CITY OF PORTLAND, MAINE
PLANNING BOARD

November 25, 2003

RE: PROP 9-Unit Subdivision, Anderson Street
ID #2002-0140, CBL #012-B-009

**ANDERSON STREET
PORTLAND, MAINE
PROP HOUSING PHASE III
SUBDIVISION PLAN**

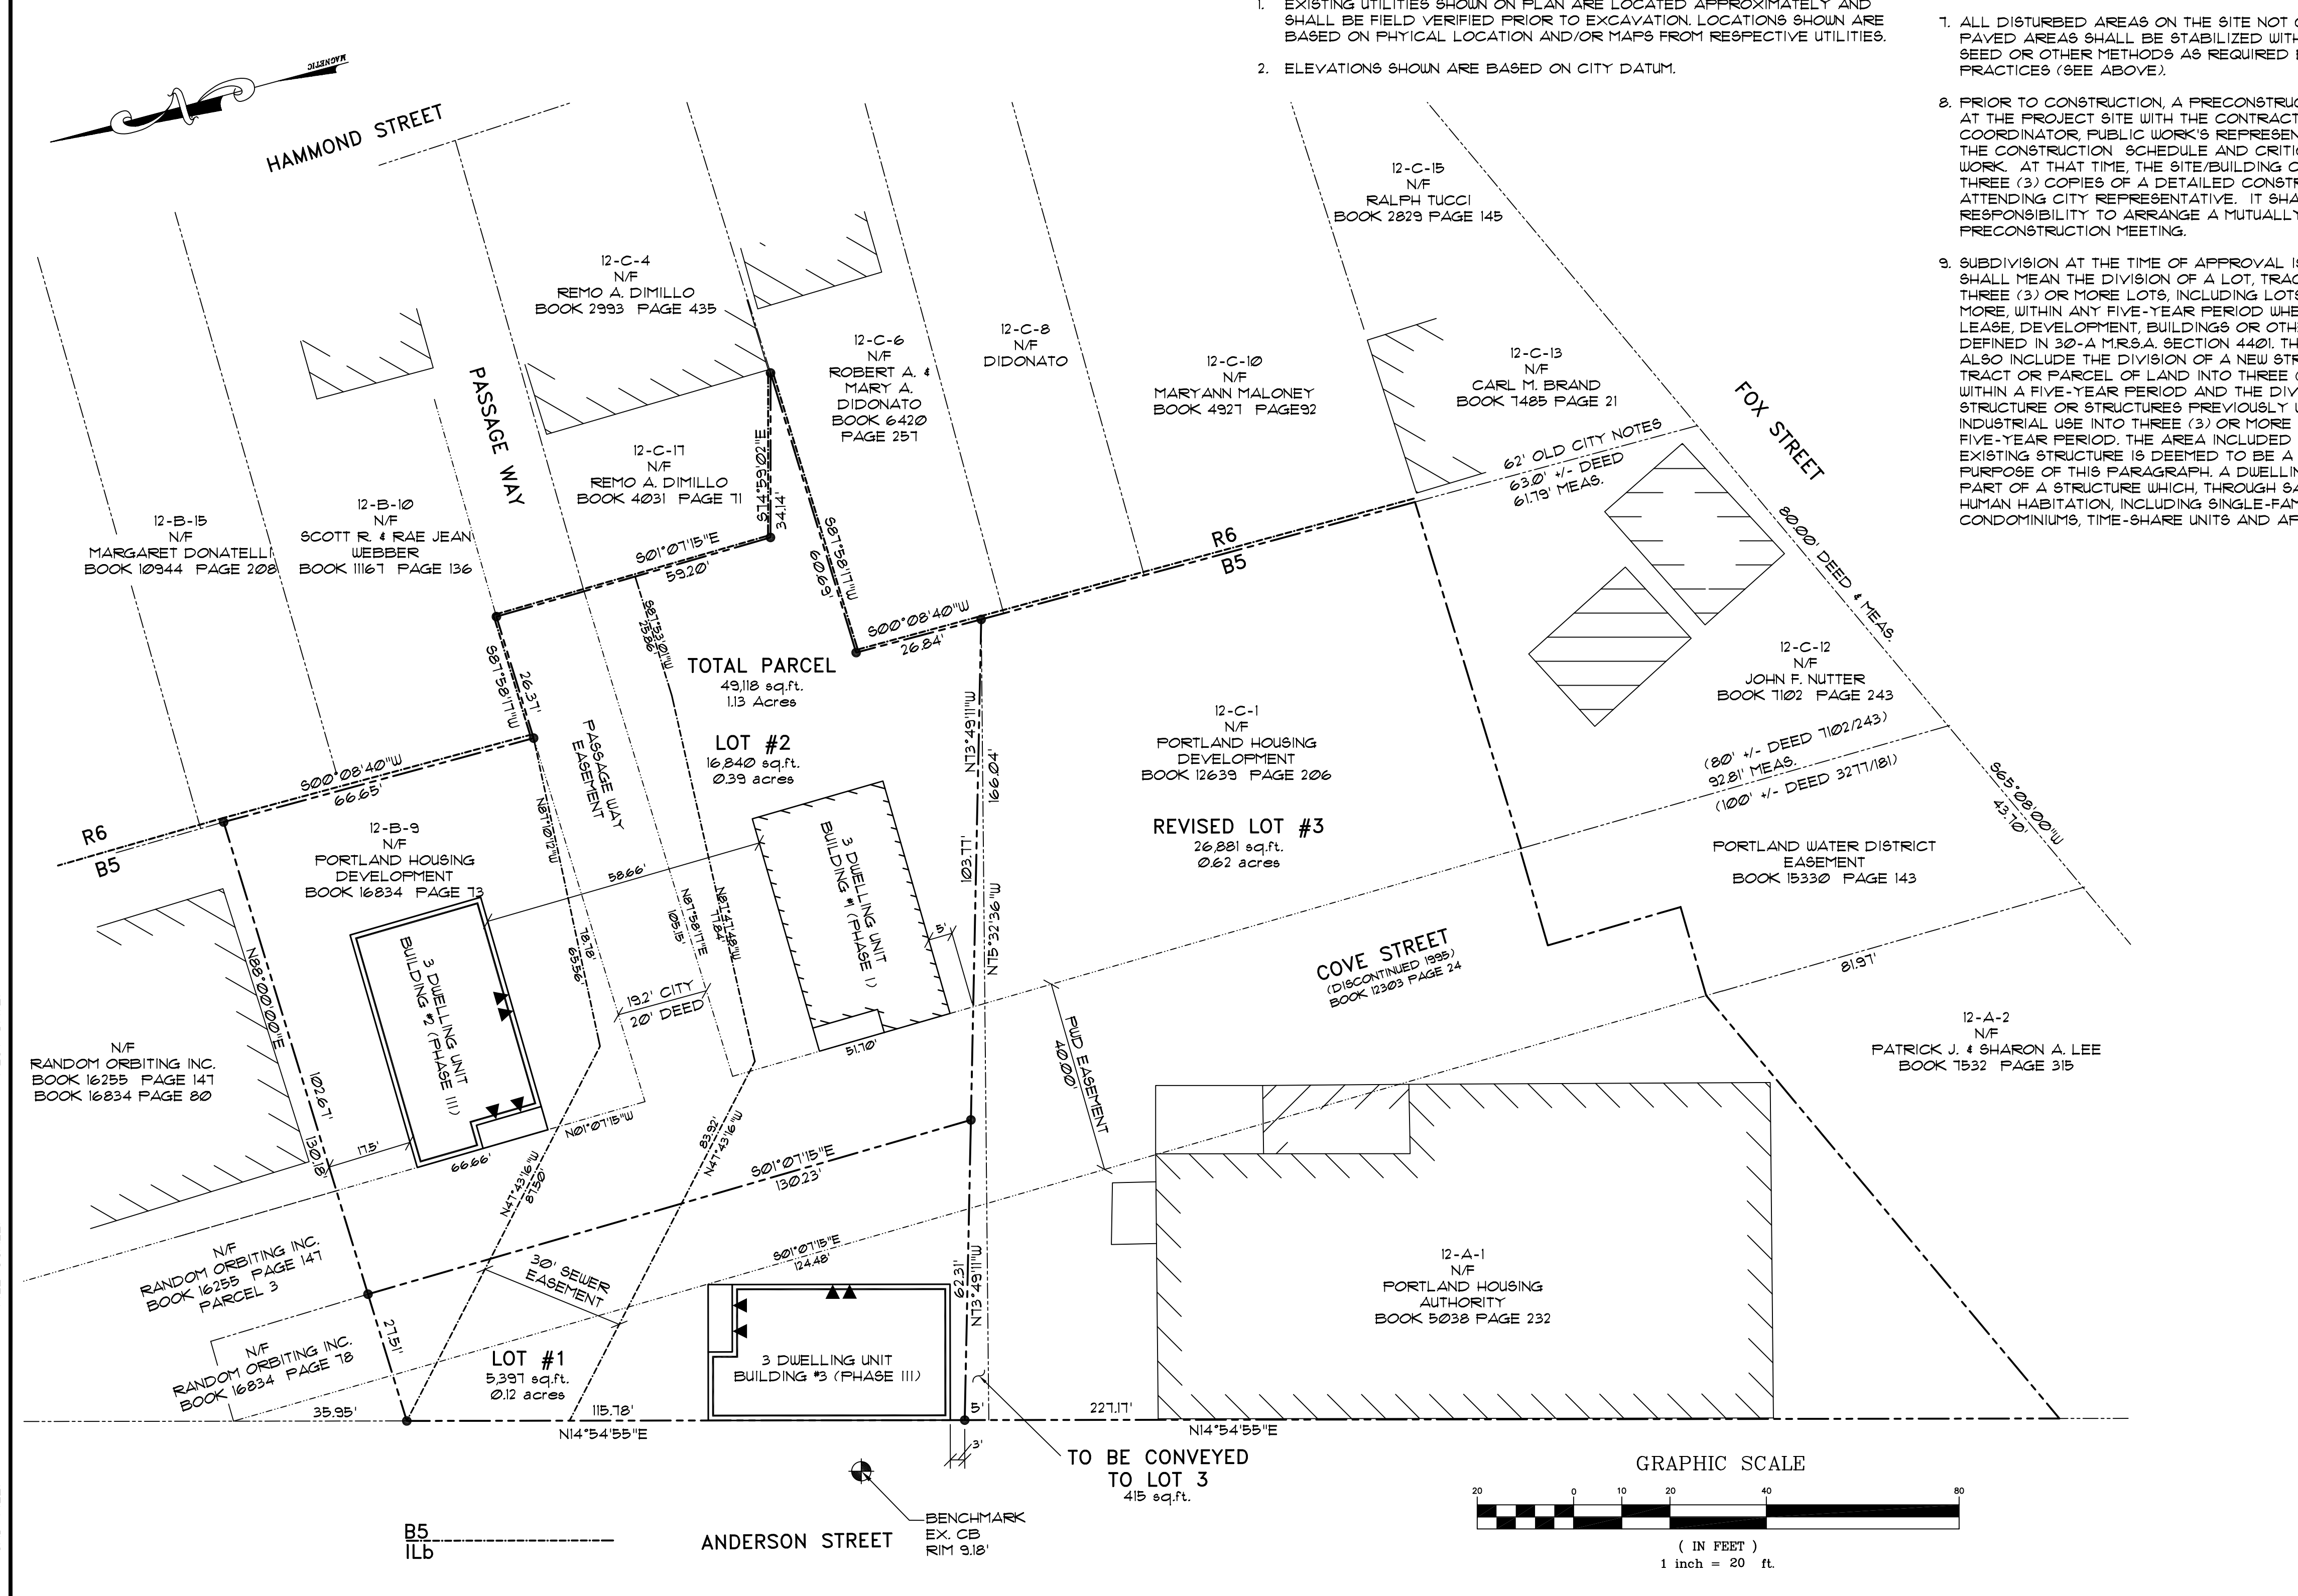
- i. that the applicant revise the subdivision plan to show a 30 ft. wide sewer easement and that the applicant provide sewer easement language for review and approval by staff.
